Lot 132 DP 31912 Christie Street, Dunheved

I refer to your recent meeting with Council's Development Panel concerning waste oil storage and treatment facility on the subject land. The following matters arising from the meeting and from preliminary consideration of the proposal are referred for your attention in the preparation of the Development Application.

PROPOSED OVERALL SITE PLAN

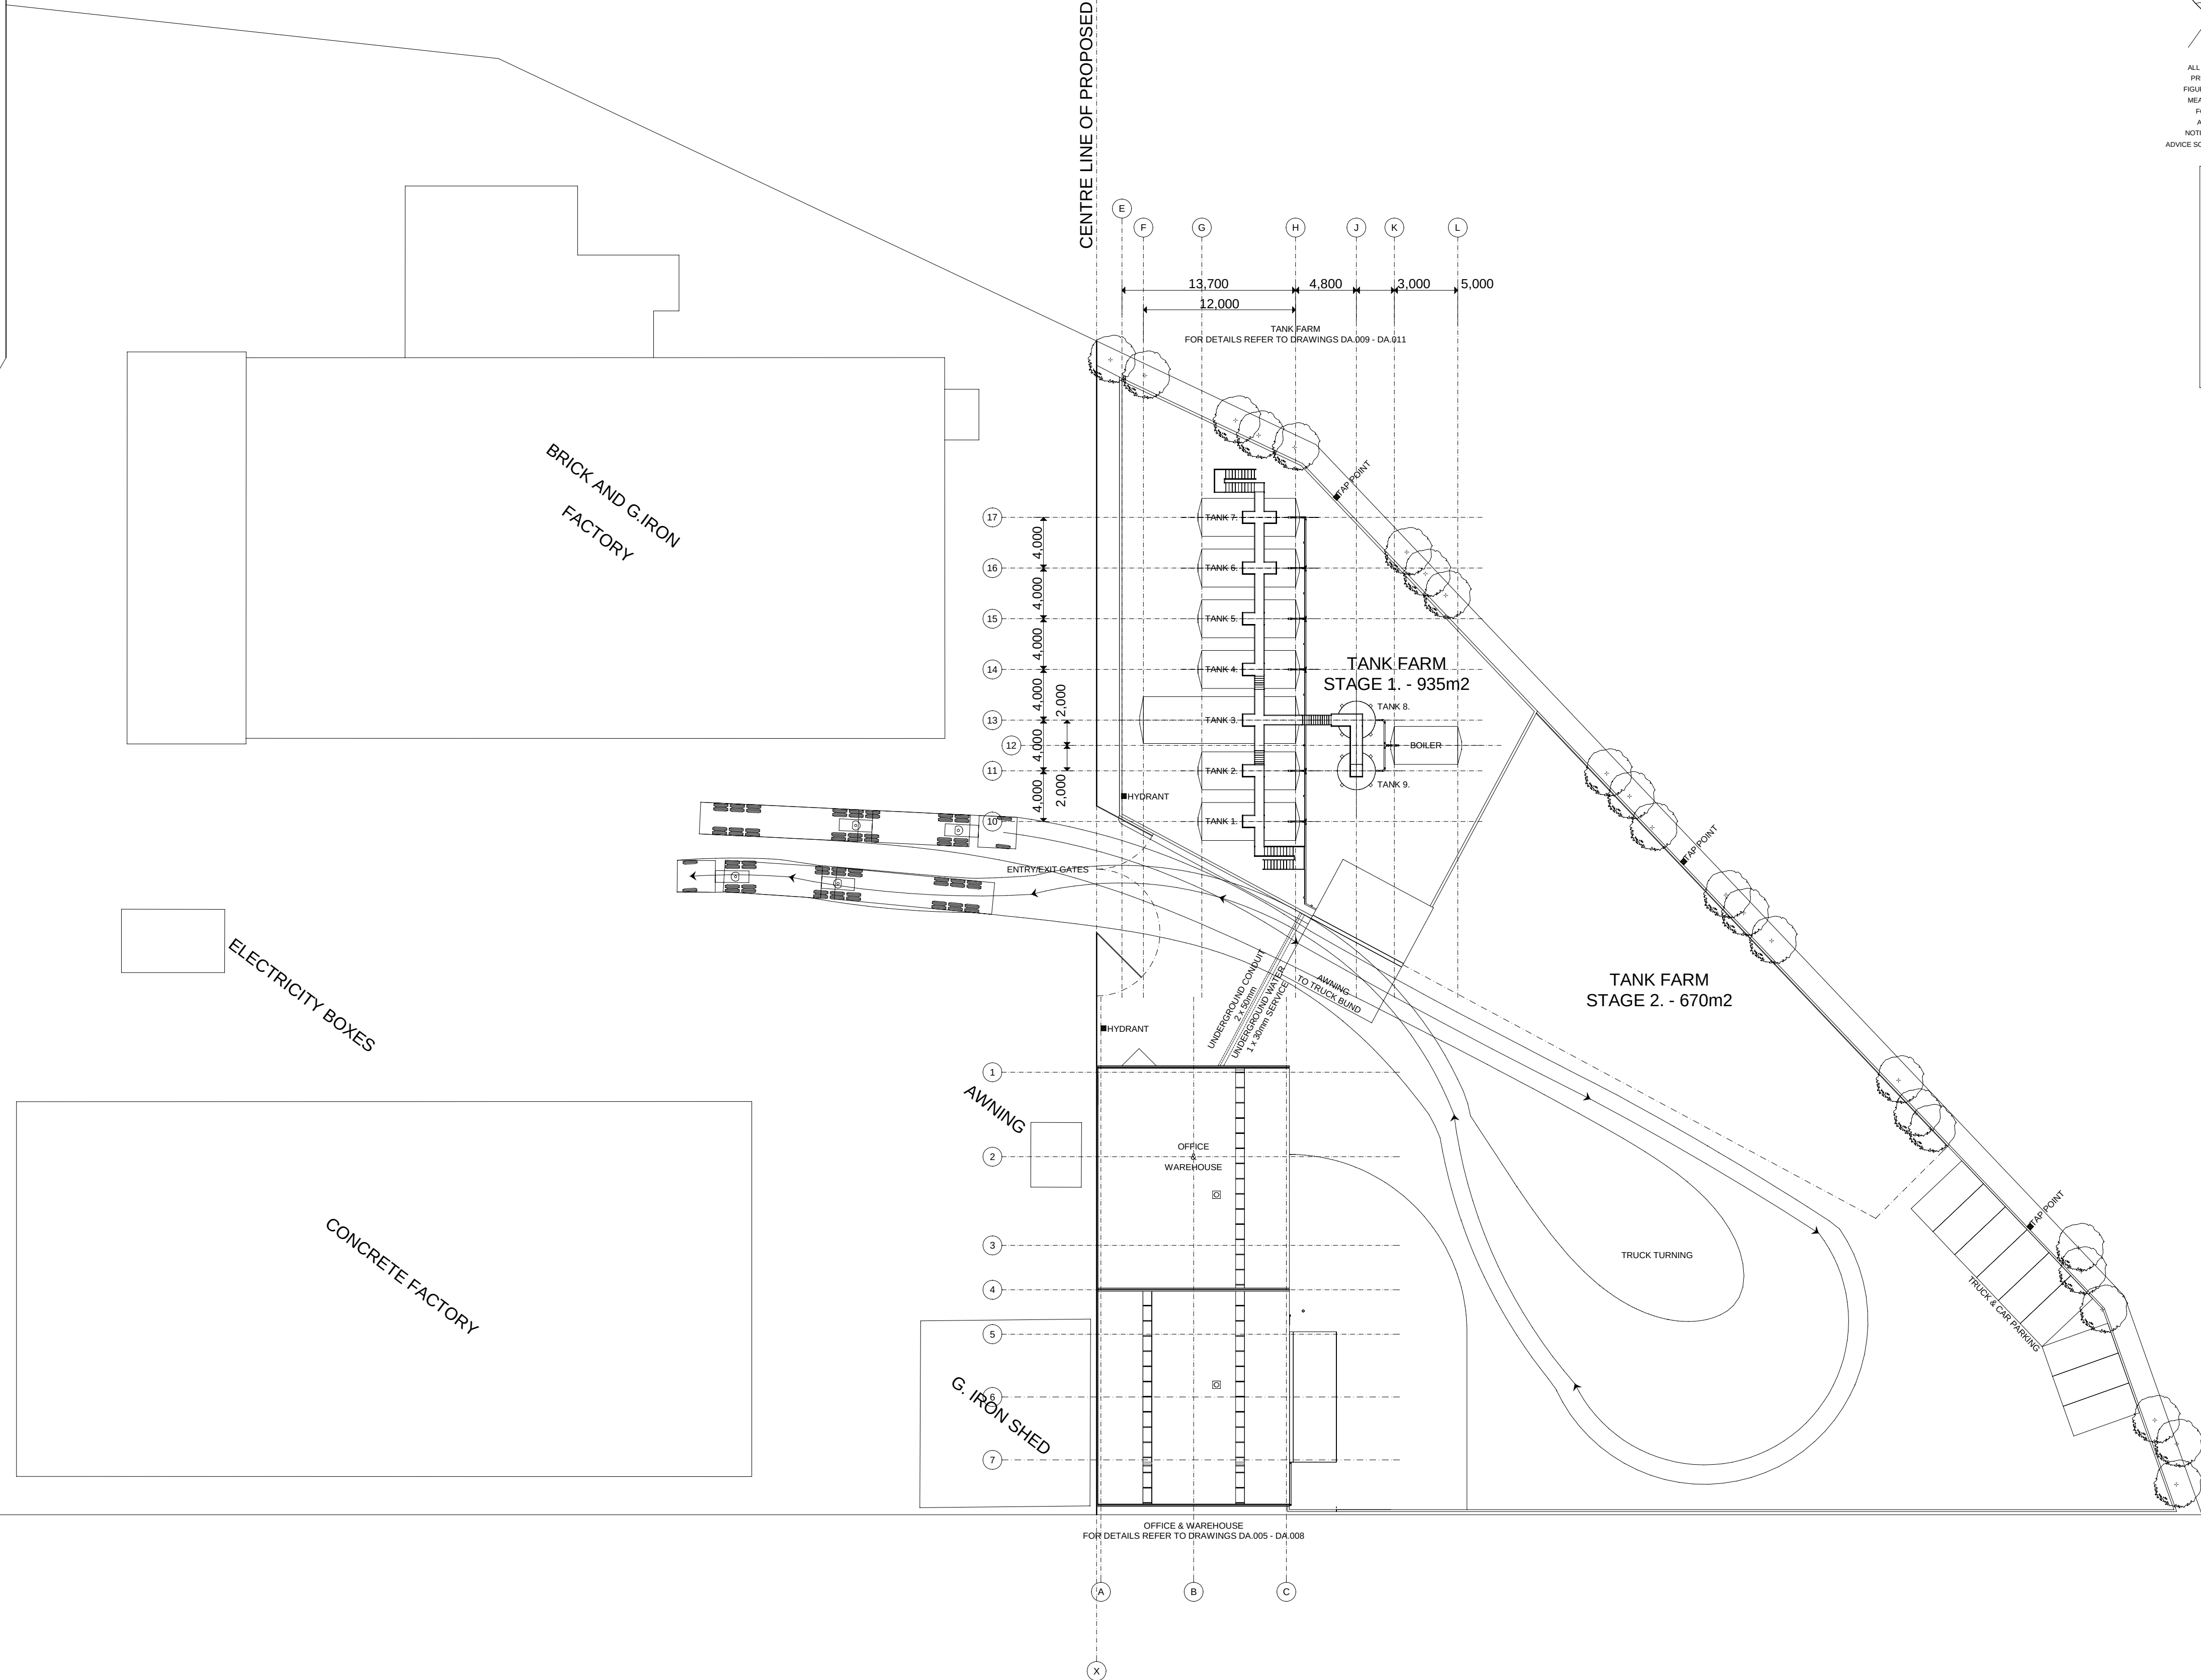
A minimum of one car space/75m² of the gross floor area of the proposed workshop is to be provided for the development. The design of the development is to accommodate access by all trucks servicing the premises.

Screening of the tanks and yard area by planting along the north-eastern boundary of the land will be required.

Full details of the proposed drainage disposal system are to be lodged with the Development Application. On-site detention of drainage will be required.

SCALE	DRAWN	CHECKED	APPROVED	DATE
1 TO 100 @ A1 R.P.		D.J.S	R.W.B	FEB. 2006
JOB		DWG NO.		REV NO.
Klekies		DA 010		A

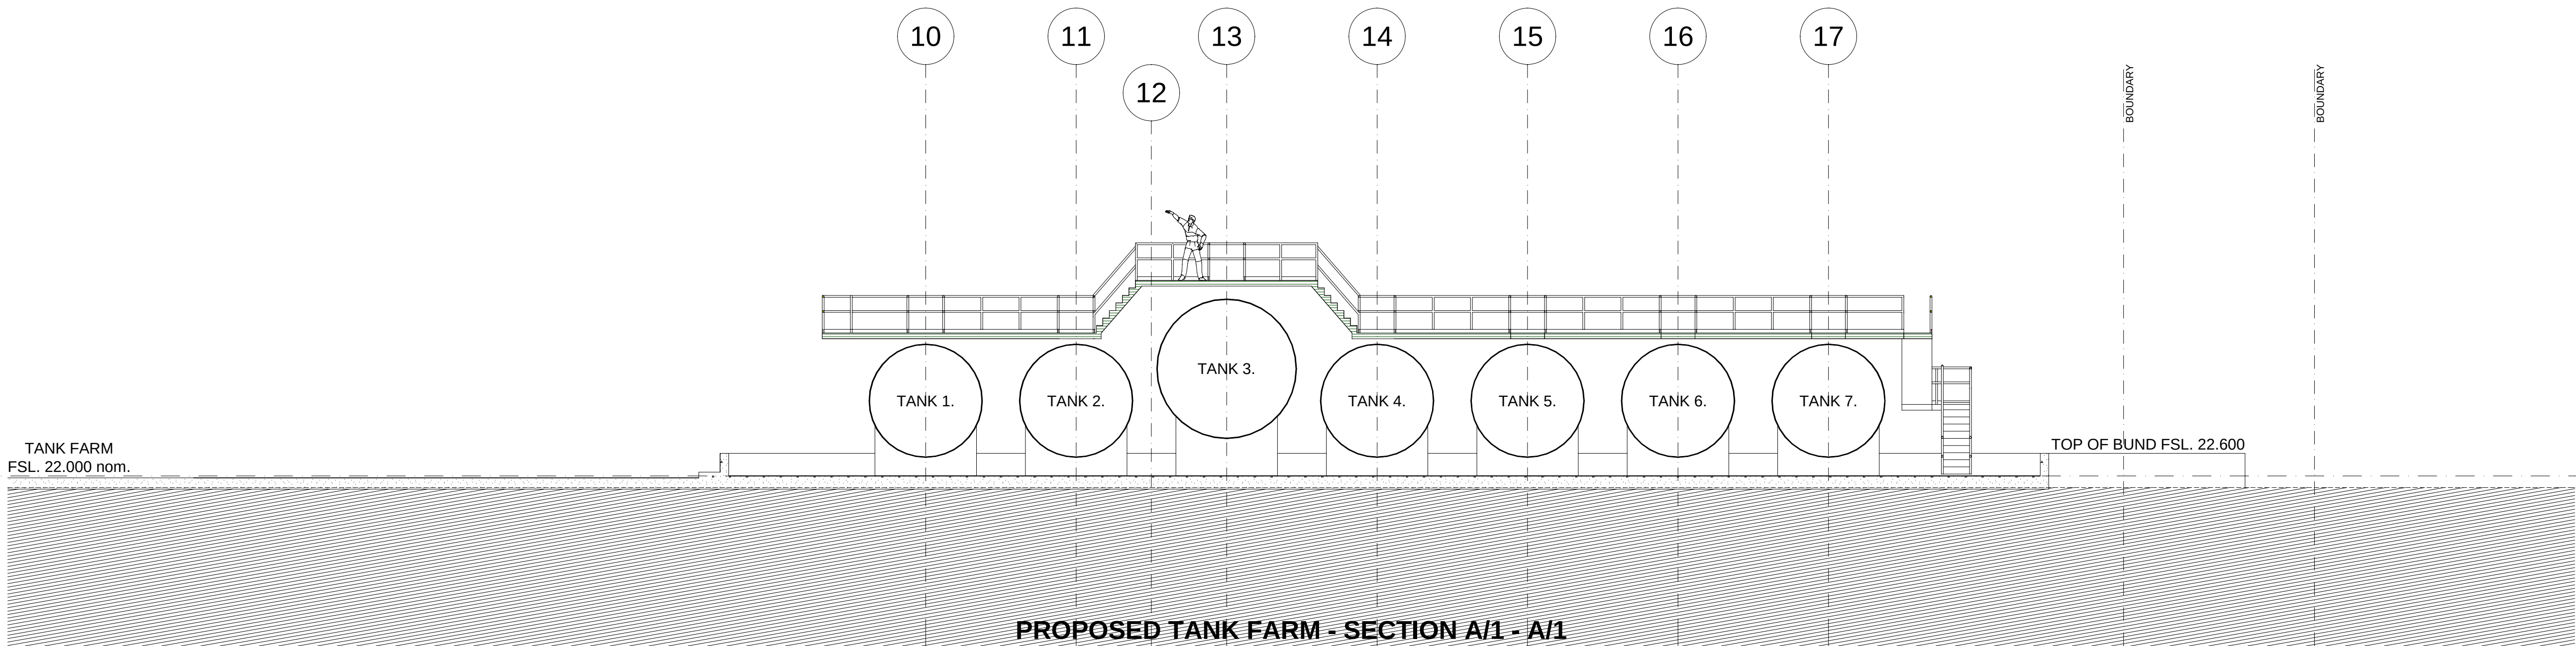
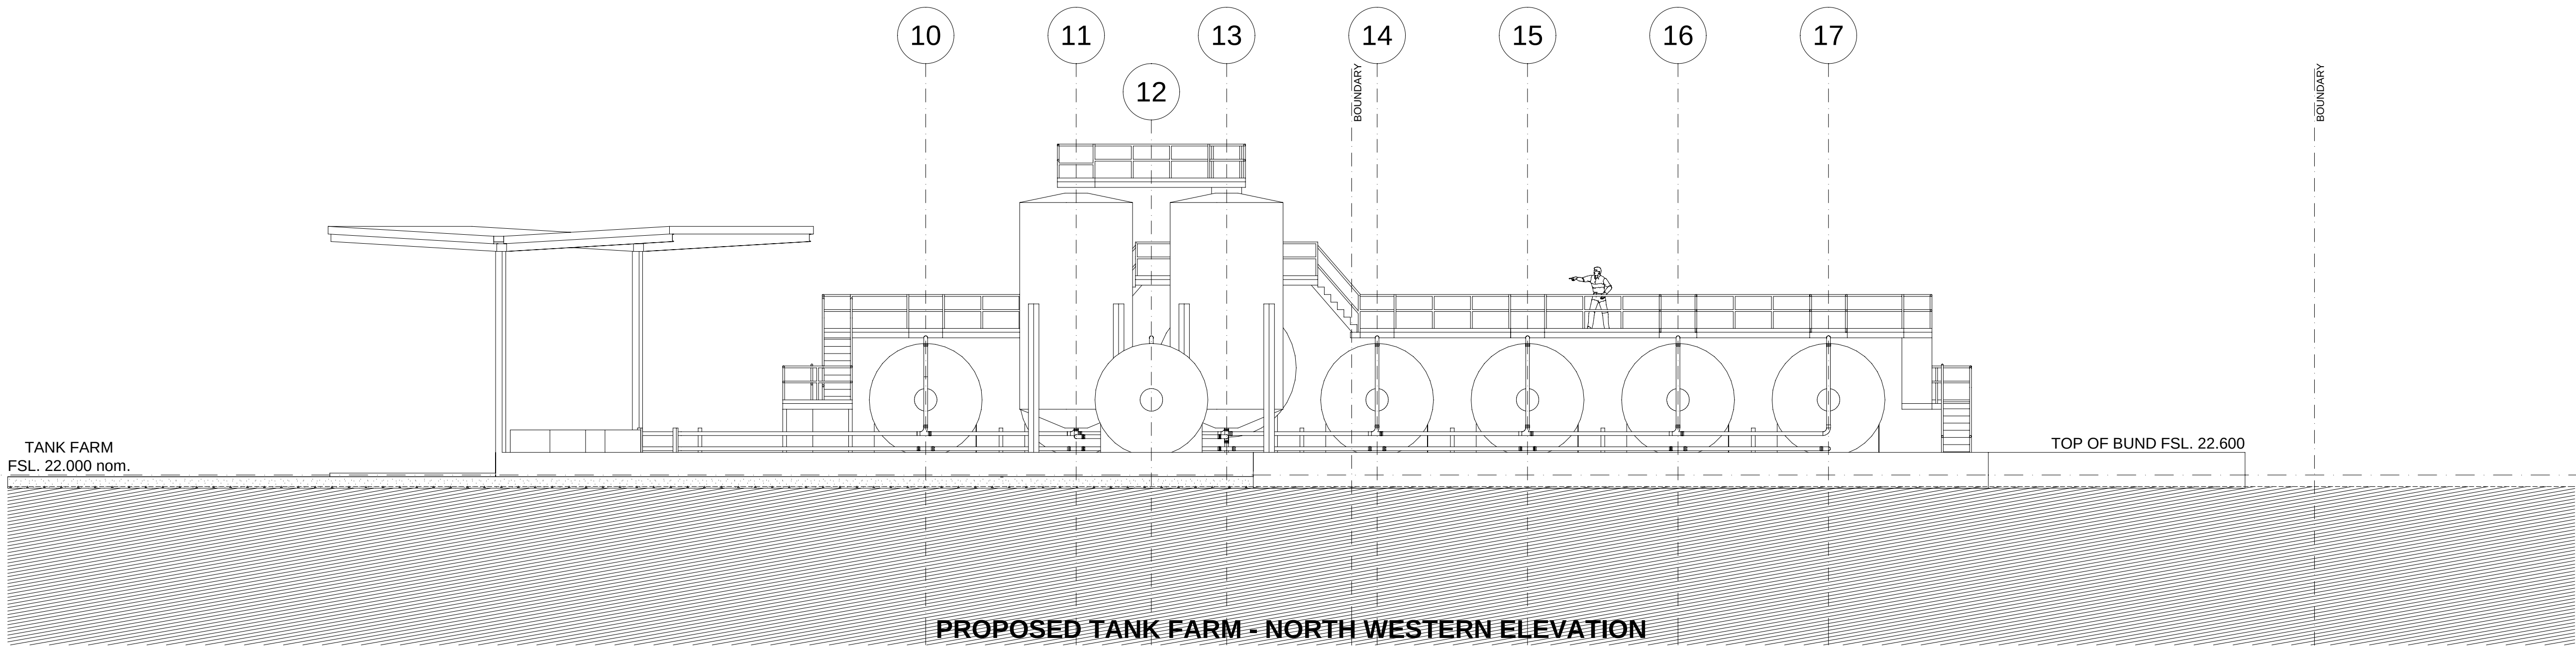
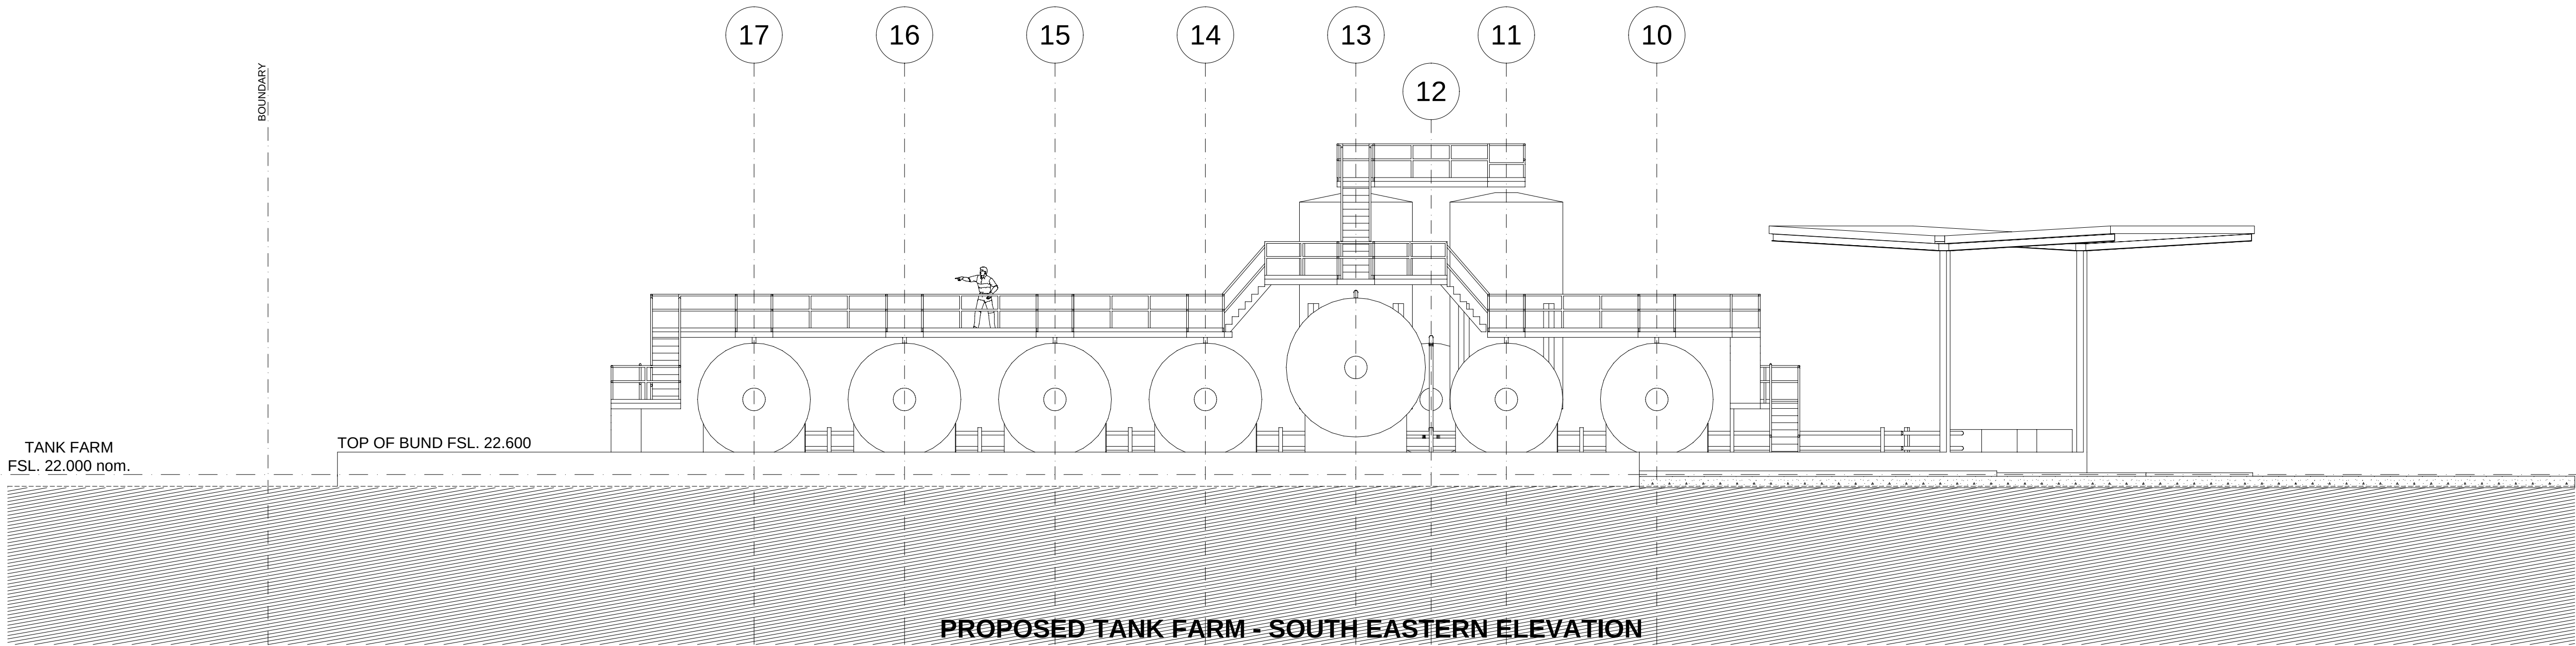
The tanks and associated bunding are to be designed to be at least 0.5m above the level of the 1 in 100 year flood i.e. variable from 21.8 – 22.6m AHD. In addition, the Development Application must satisfy Council in respect of the structural adequacy of the tank installations and prevention of any pollution potential arising during flood events.
